**Planning Department
Transportation Development Services**

November 20, 2014

Re: Gorman Warehouse, 1330 12th Street NW
Traffic Circulation Layout
Architect's Stamp dated 11-17-14 (J13-D100)

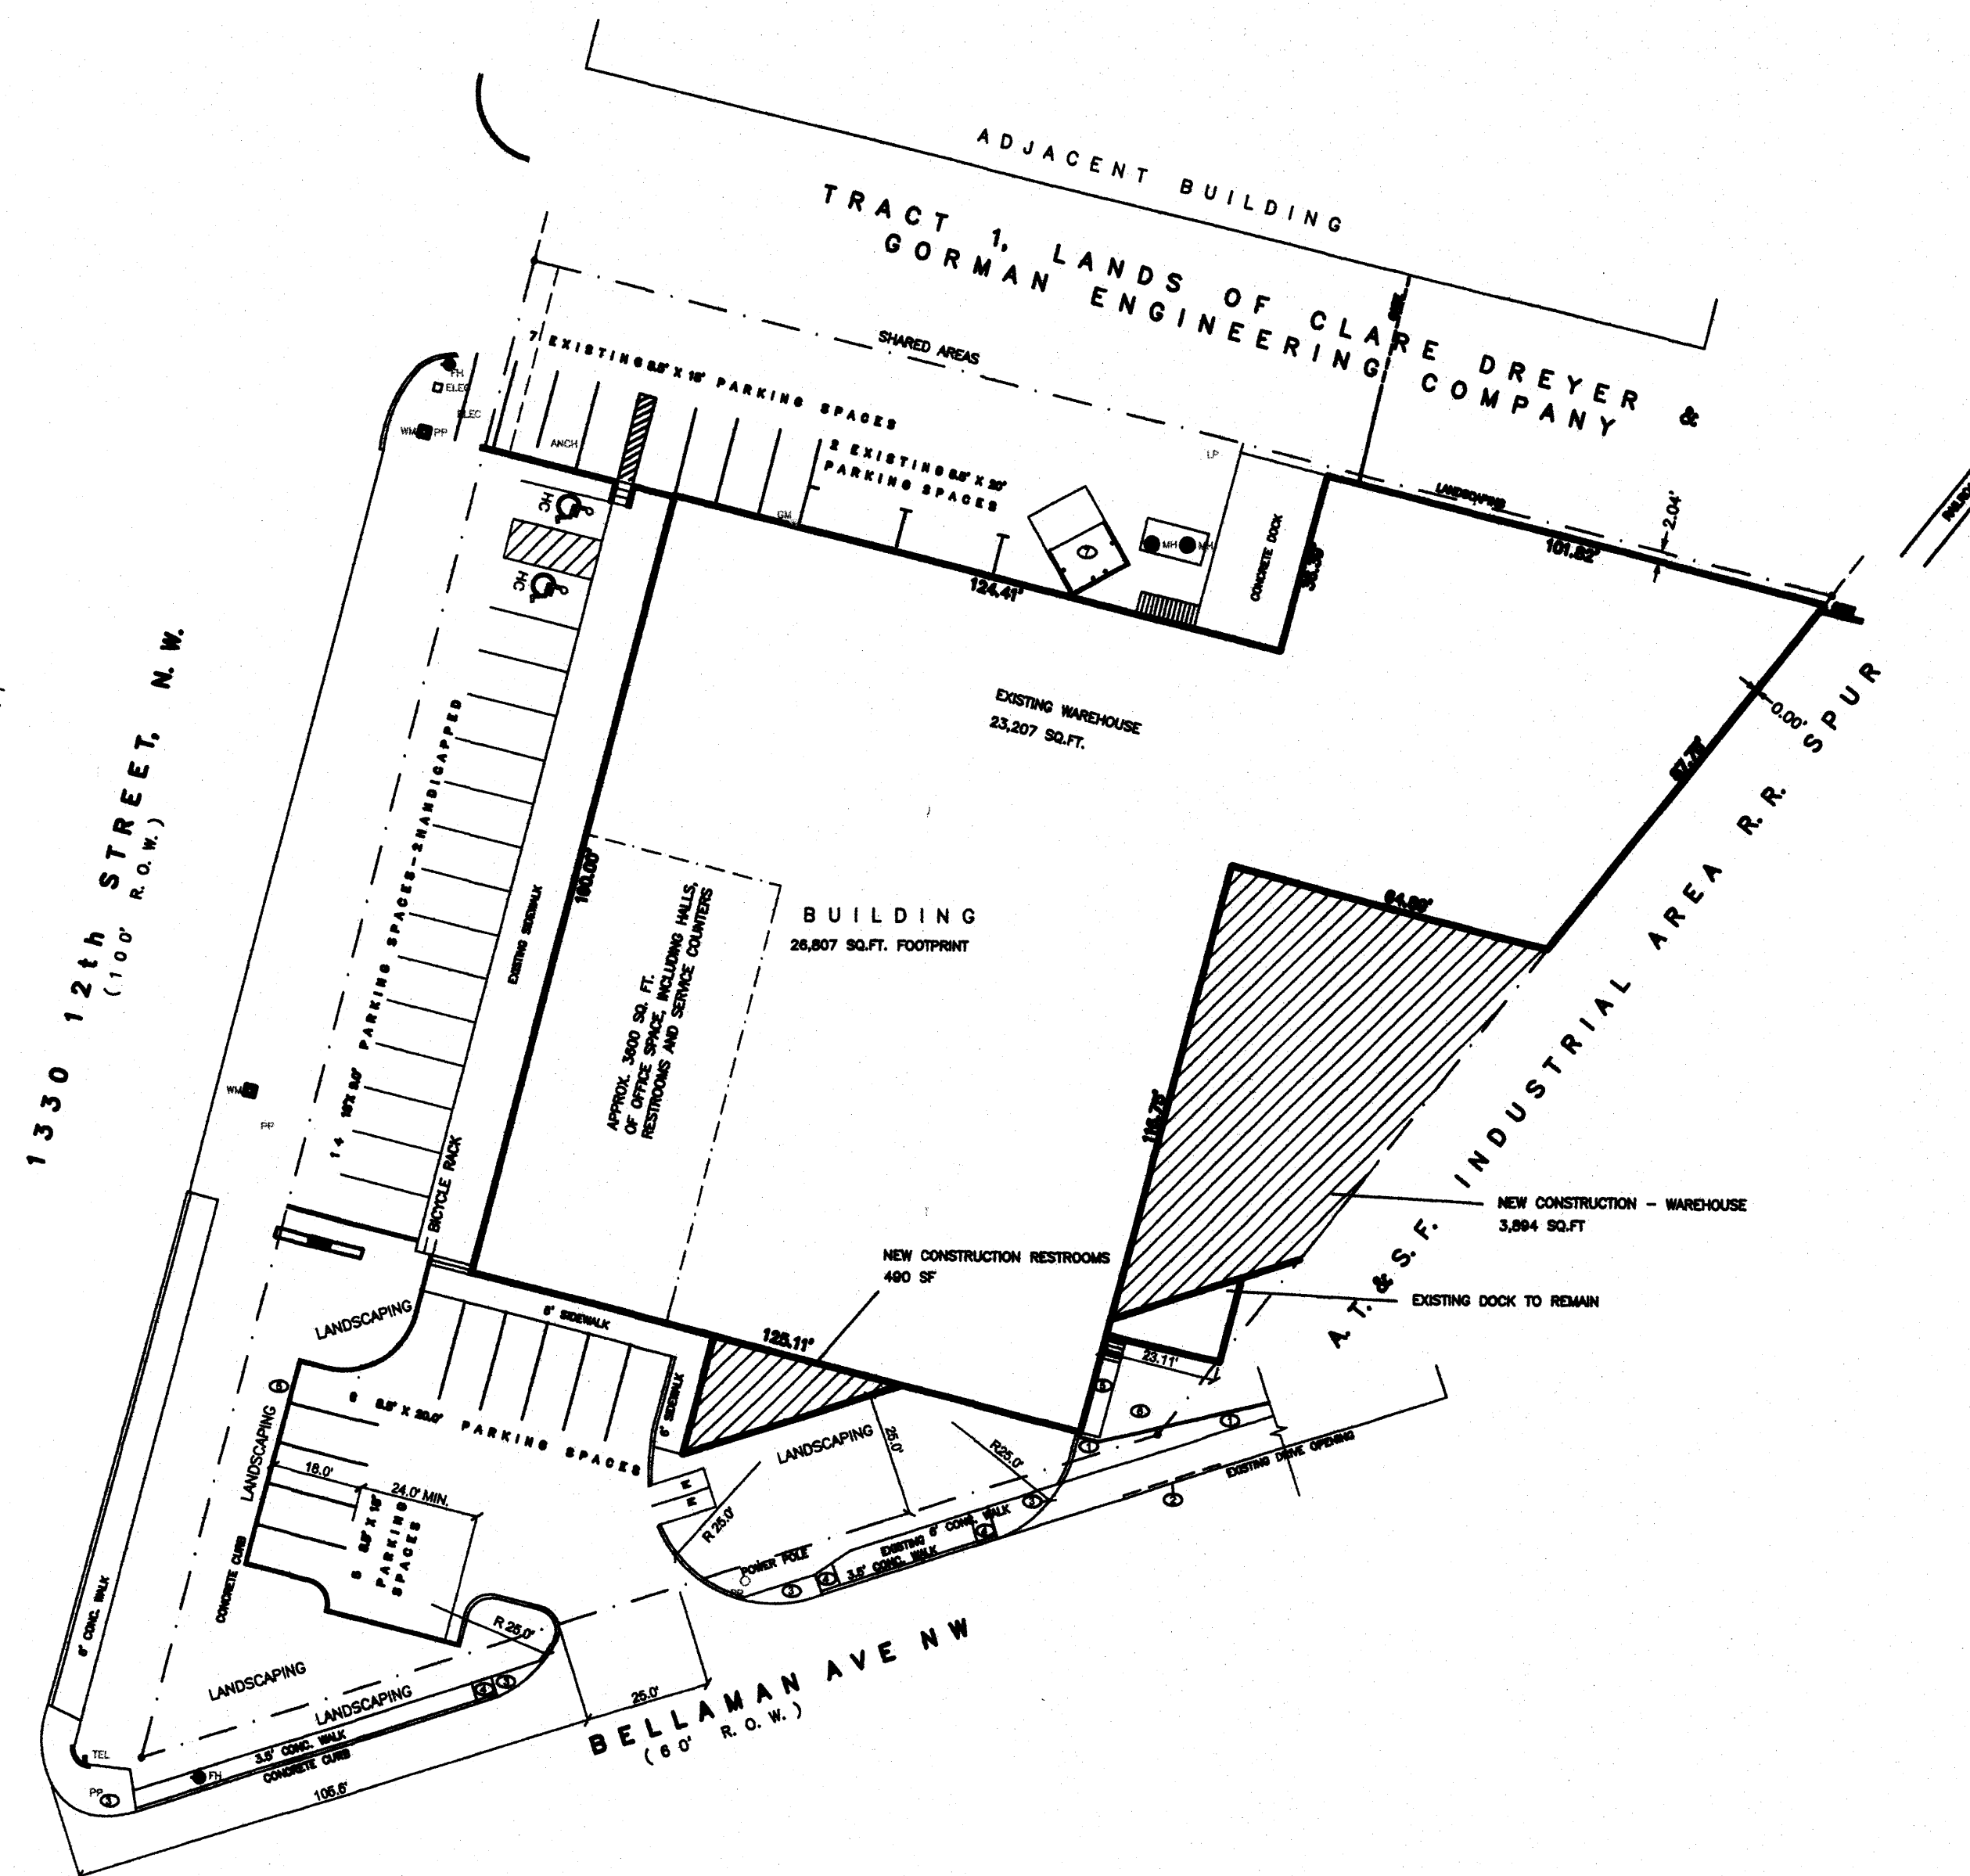
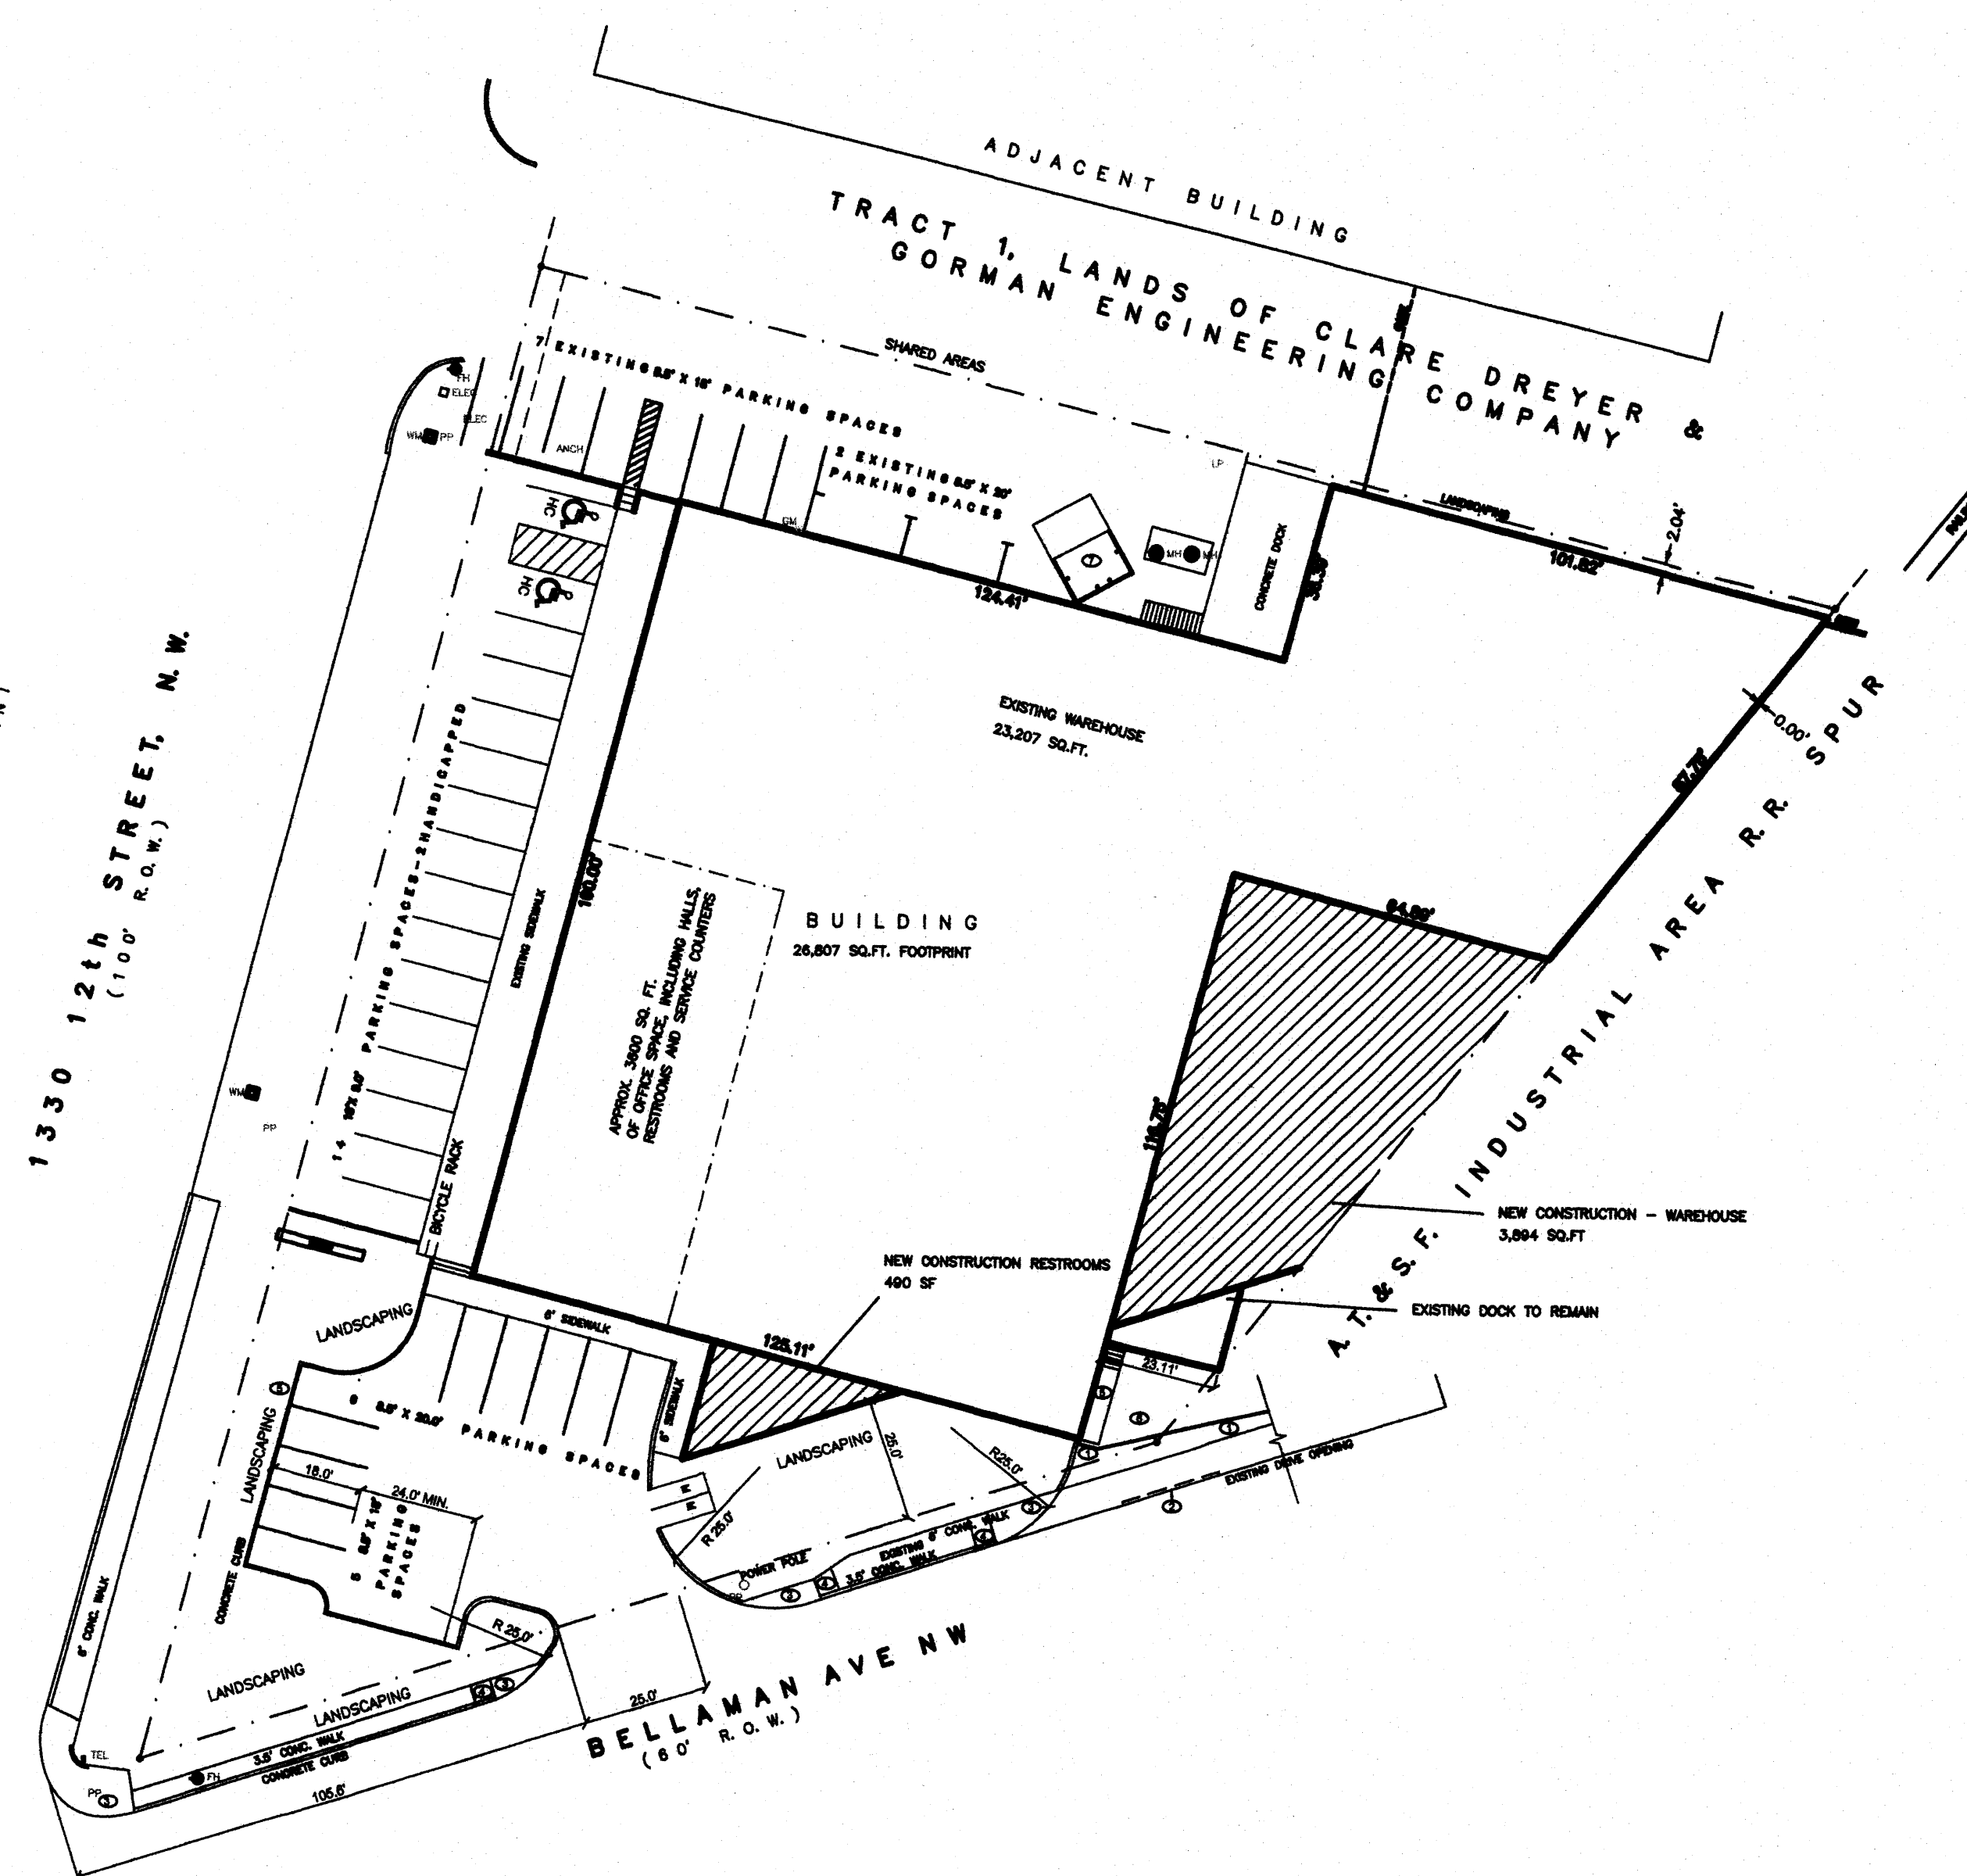
2. On the "Proposed Site Plan", label the 26,807 square foot building as "Existing". Show all existing doorways into the existing building and any new doorways if applicable. Provide legend identifying the hatched areas as new building additions, and also provide legend for the right-of-way/property line, curb, etc.

3. Label all existing sidewalk within the right-of-way and within the site as "existing" to differentiate it clearly from the new sidewalk. Call out the width of the existing sidewalk that runs adjacent to the west side of the existing building. Call out width of existing access off of 12th Street on the north side of the site. Show and label existing laydown curb along 12th Street and show dimension of driving aisle along the parking spaces along the west side of the building by providing a dimension from the end of the parking spaces to the laydown curb.

4. Identify the existing curb cut for the property off of Bellamah Avenue immediately west of the corner of the building. This existing curb cut will need to be replaced with new 6-foot sidewalk and curb at full height. Call out this replacement on the plan.

5. Upsize the text showing the width and length for all parking spaces on the proposed plan. Show width of the handicapped spaces, and identify the width of the van access aisle. The handicap accessible spaces must be a minimum of 8.5 feet in width. The van access aisle must be a minimum of 8 feet wide.

8. Show all curb radii for the new parking lot. Provide the dimension for the keyway along the south side of the new parking lot. The minimum width required for the keyway is five feet.

9. Per the DPM, a 6-foot wide ADA accessible pedestrian pathway is required from the public sidewalk to the building entrances. Please provide this pathway either from the sidewalk on Bellamah Avenue or from 12th Street.

10. Provide a 6-inch to 8-inch high concrete barrier curb or other acceptable barrier between parking lot and the adjacent sidewalks and landscaped areas.

11. Design delivery vehicle route needs to be shown.
12. It is not apparent what type of pavement surface is being proposed. A hard driving surface will be required as part of this proposed project for parking area and drive aisles.

13. Show the clear sight triangle for the new drive entrance off of Bellamah Avenue as per Page 23-74 of the DPM. Please add the following note to the clear sight triangle: "Landscaping and signage will not interfere with clear sight requirements. Therefore, signs, walls, trees, and shrubbery between 3 and 8 feet tall (as measured from the gutter pan) will not be acceptable in this area."

14. Provide details for the new ramps as per Keyed Notes 3 and 4, and upsize keyed note call-outs on the plan view. Make the ramps a minimum of 4 feet wide, and then transition to existing sidewalk widths. Please specify the City Standard Drawing Number when applicable for construction of new curb, sidewalk, and handicapped ramps within public right-of-way.

15. Extend concrete sidewalk around the existing fire hydrant close to the intersection of Bellamah Avenue for ADA accessibility.

16. Provide correct spelling of Bellamah Avenue on the proposed site plan.
